CITY OF ALBUQUERQUE

March 14, 2023

Re: Take 5 Car Wash
10415 Central Ave. NE
Traffic Circulation Layout
Engineer's/Architect's Stamp XX-XX-XX (L21-D059B)

CIRCULATION PLAN

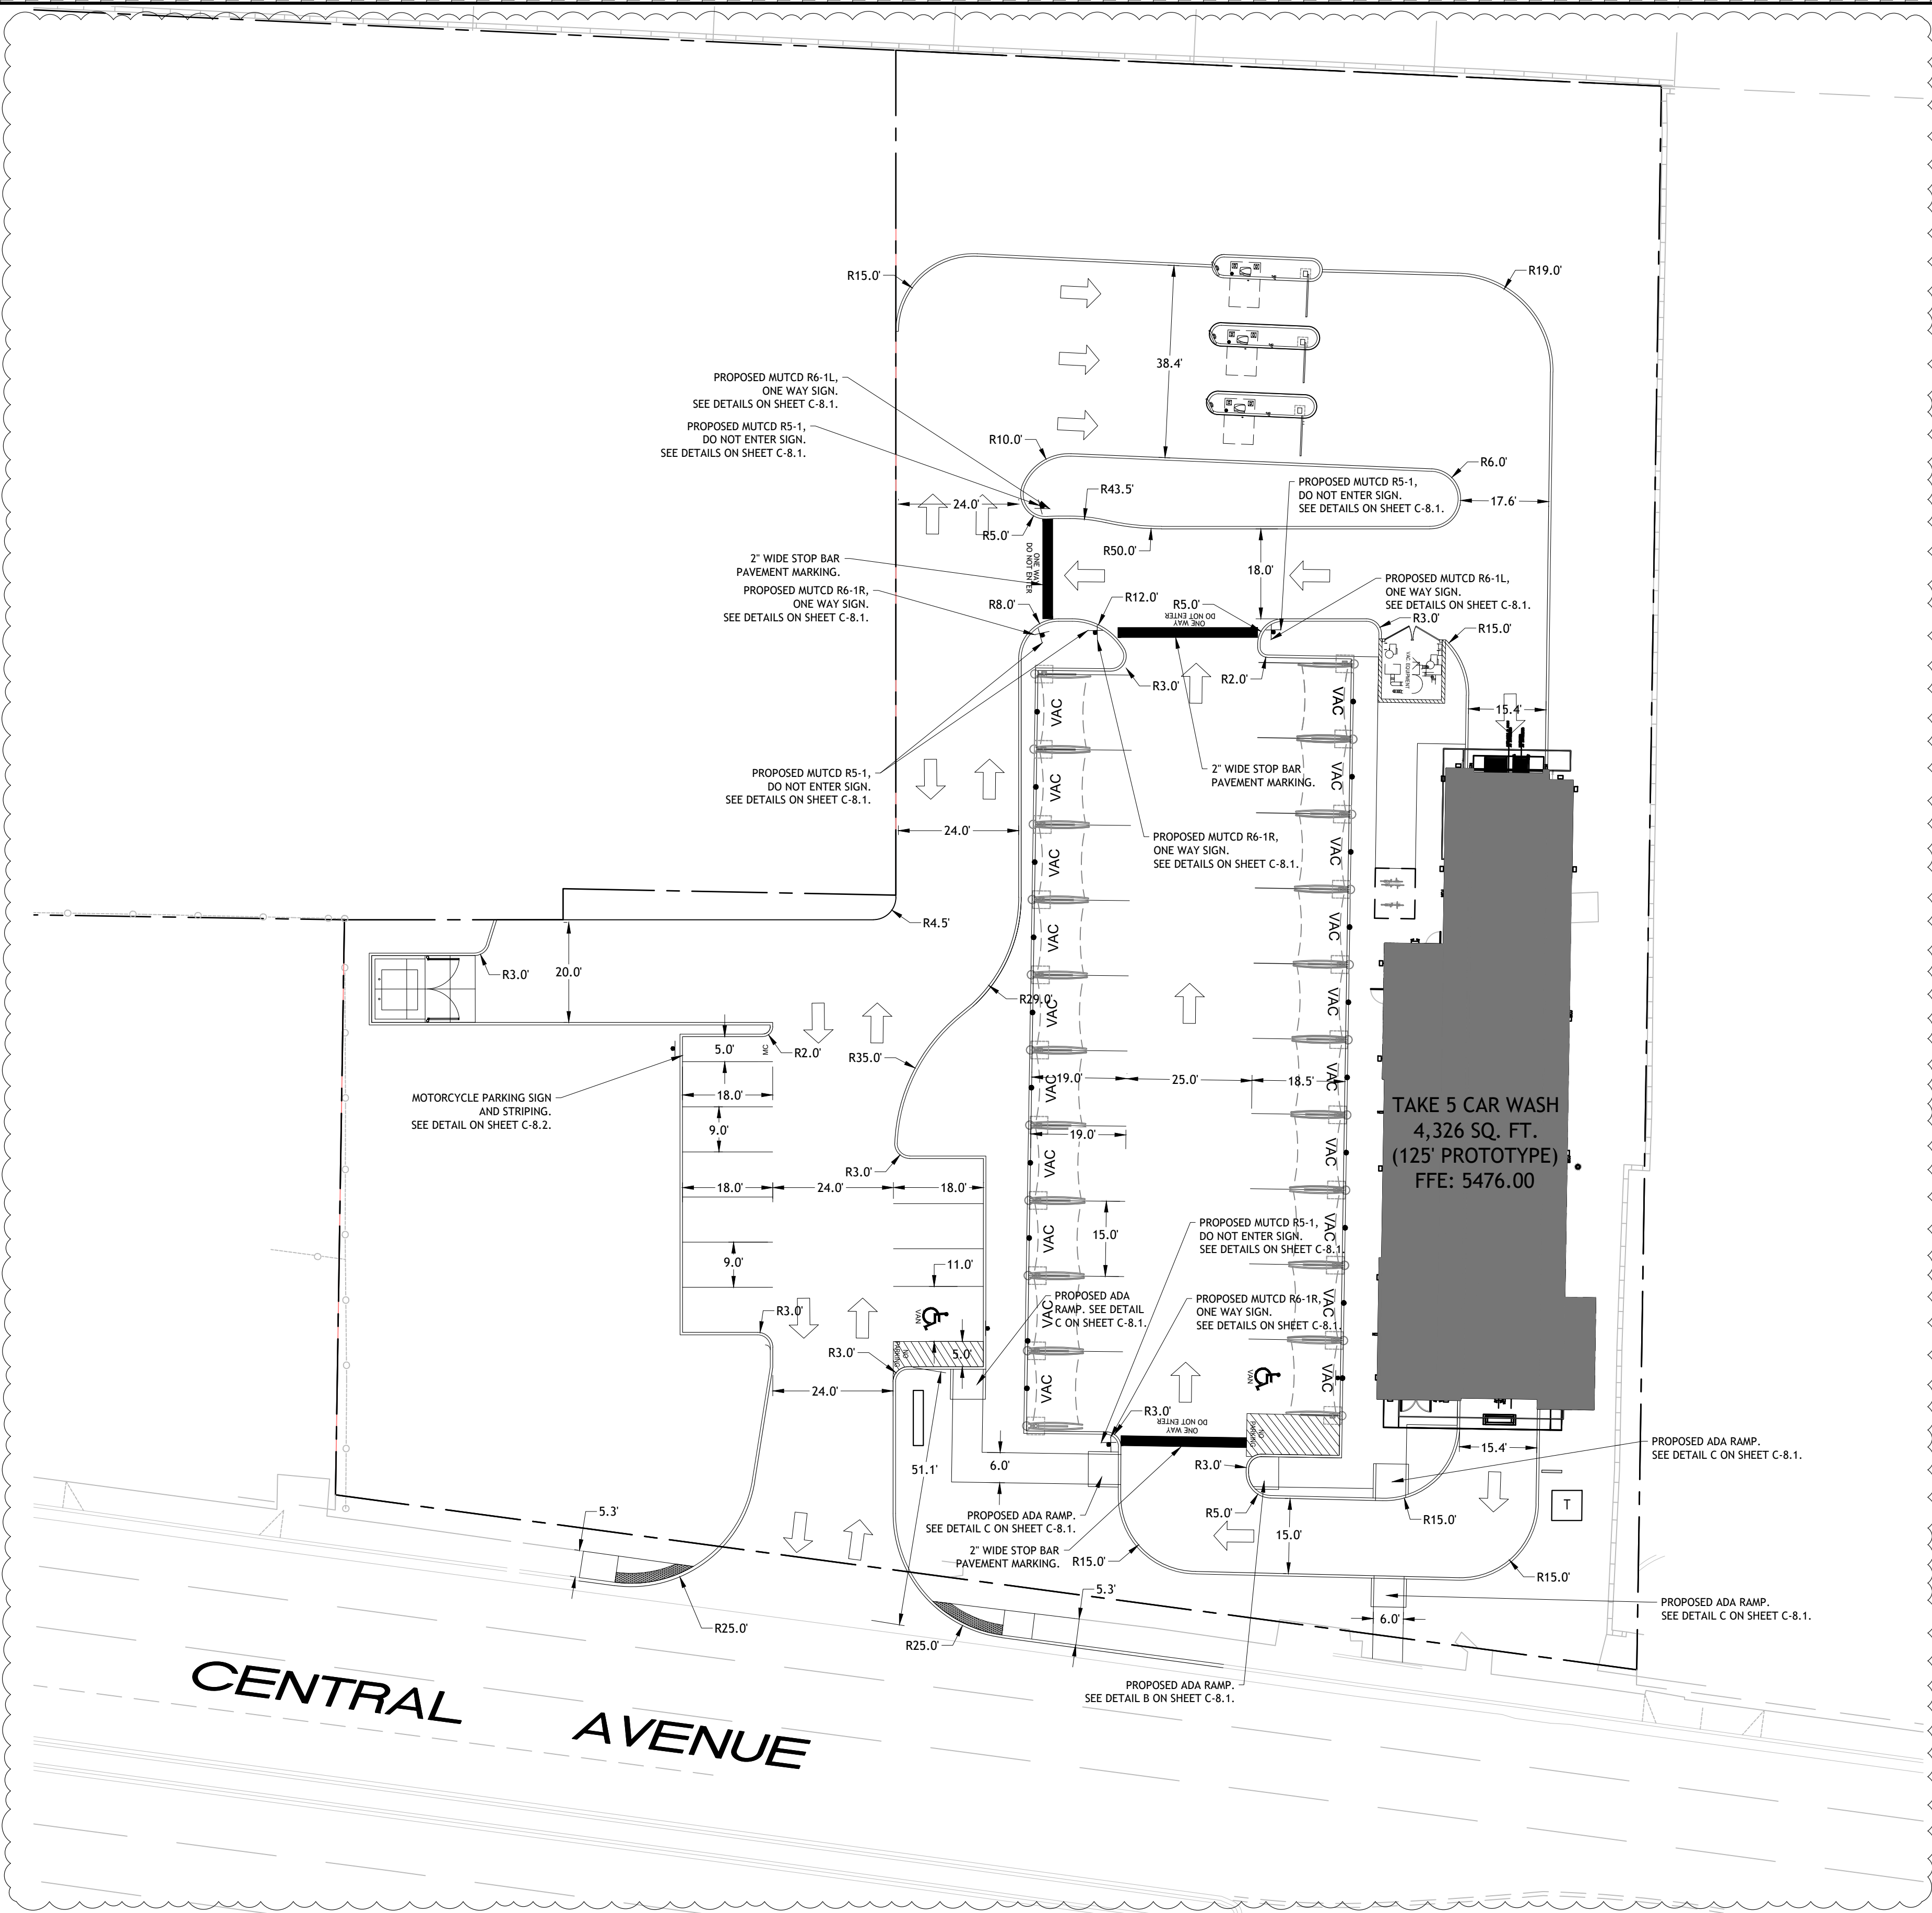
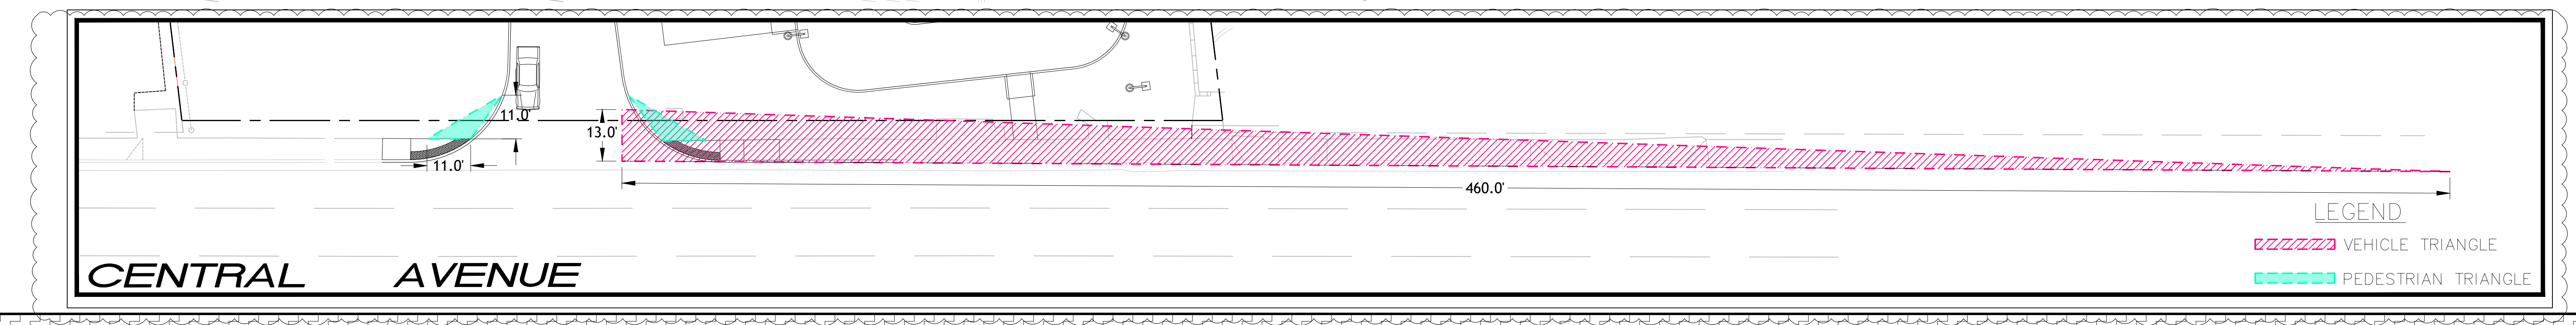
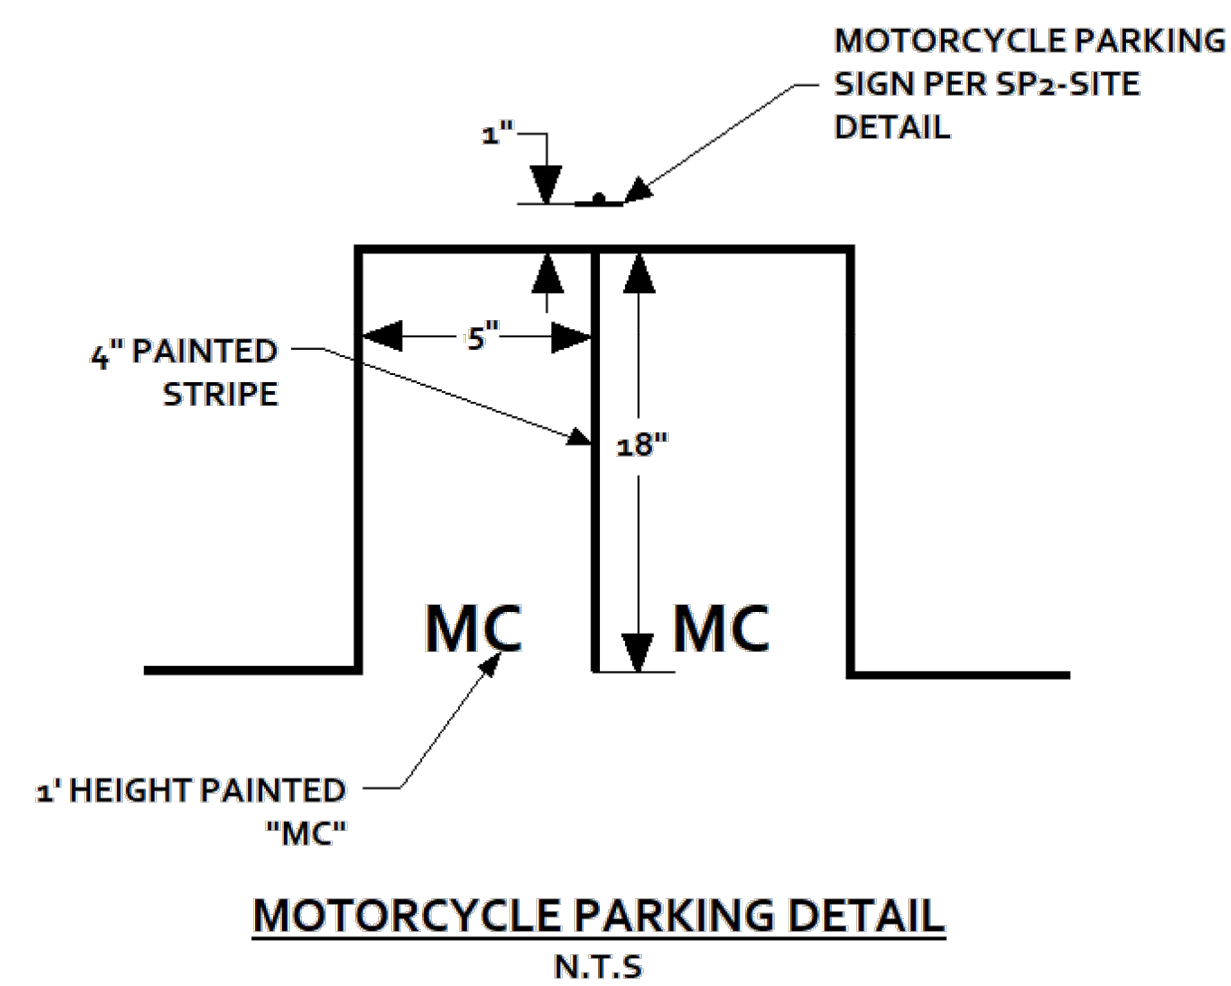
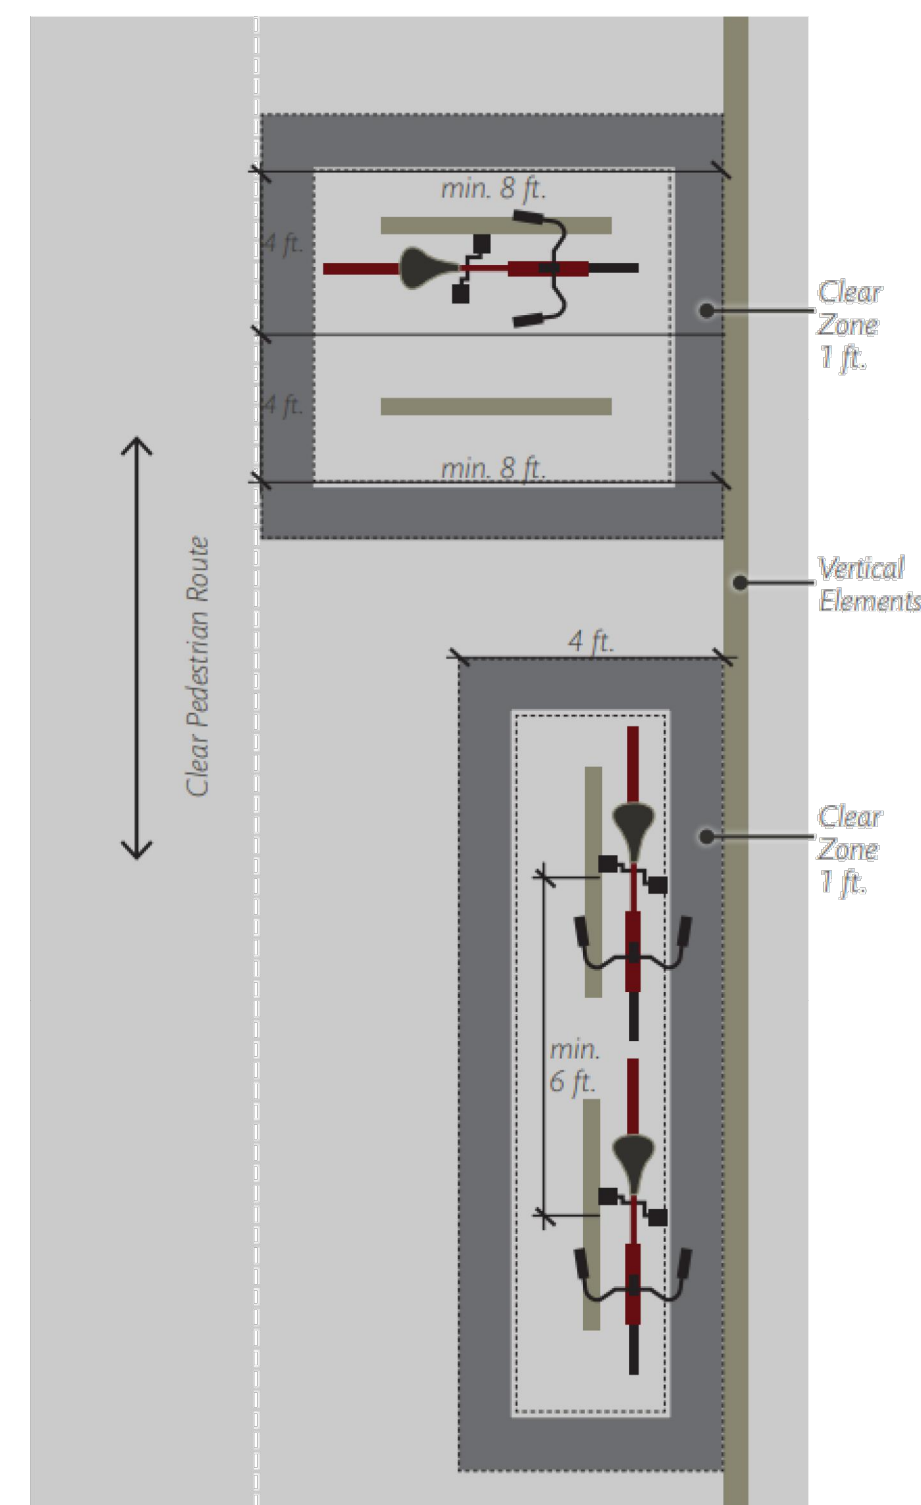
1. The traffic circulation layout must be stamped, signed, and dated by an engineer or architect licensed in the state of New Mexico.
2. Identify all existing access easements and rights of way width dimensions.
3. Identify the right of way width, medians, curb cuts, and street widths on Central Ave.
4. Site access's throat length should be minimum 50 ft. please show this dimension on the site plan.

5. Please provide the width for the existing driveway access off Central.
6. ADA curb ramps at the driveway access must be updated to current standards and have truncated domes installed.
7. The ADA accessible parking sign must have the required language per 66-7-352.4C NMSA 1978 **"Violators Are Subject to a Fine and/or Towing."** Please call out detail and location of signs.

8. The ADA access aisles shall have the words **"NO PARKING"** in capital letters, each of which shall be at least one foot high and at least two inches wide, placed at the rear of the parking space so as to be close to where an adjacent vehicle's rear tire would be placed. (66-1-4.1. B NMSA 1978)

9. Motorcycle parking spaces shall be designated by its own conspicuously posted upright sign, either free-standing or wall mounted per the zoning code.

10. The pavement marking "MC" should be shown in the opposite direction for motorcycles entering the parking space.
11. All bicycle racks shall be designed according to the following guidelines:

12. Bicycle racks shall be sturdy and anchored to a concrete pad.
13. A 1-foot clear zone around the bicycle parking stall shall be provided.
14. Bicycle parking spaces shall be at least 6 feet long and 2 feet wide.

15. List radii for all curves shown; for passenger vehicles. Radius for delivery trucks, fire trucks, etc. is 25 ft. or larger.
16. Per the IDO, a 6 ft. wide ADA accessible pedestrian pathway is required from the public sidewalk to the building entrances. Please clearly show this pathway and provide details.

17. Per DPM, a 6 ft. wide ADA accessible pedestrian pathway is required from the ADA parking stall access aisles to the building entrances. Please clearly show this pathway and provide details.

18. ADA accessible pedestrian pathway should not be placed behind parking space or adjacent to a vehicular way. Vehicle and pedestrian/wheel chair conflicts should be avoided as much as possible.

19. Refuse vehicle maneuvering shall be contained on-site. The refuse vehicle shall not back into the public right of way.; provide a copy of refuse approval.

20. Provide a copy of Fire Marshal approval.
21. All one-way drives shall have "One Way" and "Do Not Enter" signage and pavement markings. Please show detail and location of posted signs and striping.

22. The minimum drive through lane width is 12 feet with a 25-foot minimum radius (inside edge) for all turns. (A 15-foot radius can be used with an increase in lane width to 14 feet). Please dimension all lane widths and radii.

23. Clear Sight Triangle should start from the back of the sidewalk.
24. Please specify the City Standard Drawing Number when applicable.
25. Add a note stating "All broken or cracked sidewalk must be replaced with sidewalk and curb & gutter." A build note must be provided referring to the appropriate City Standard drawing.
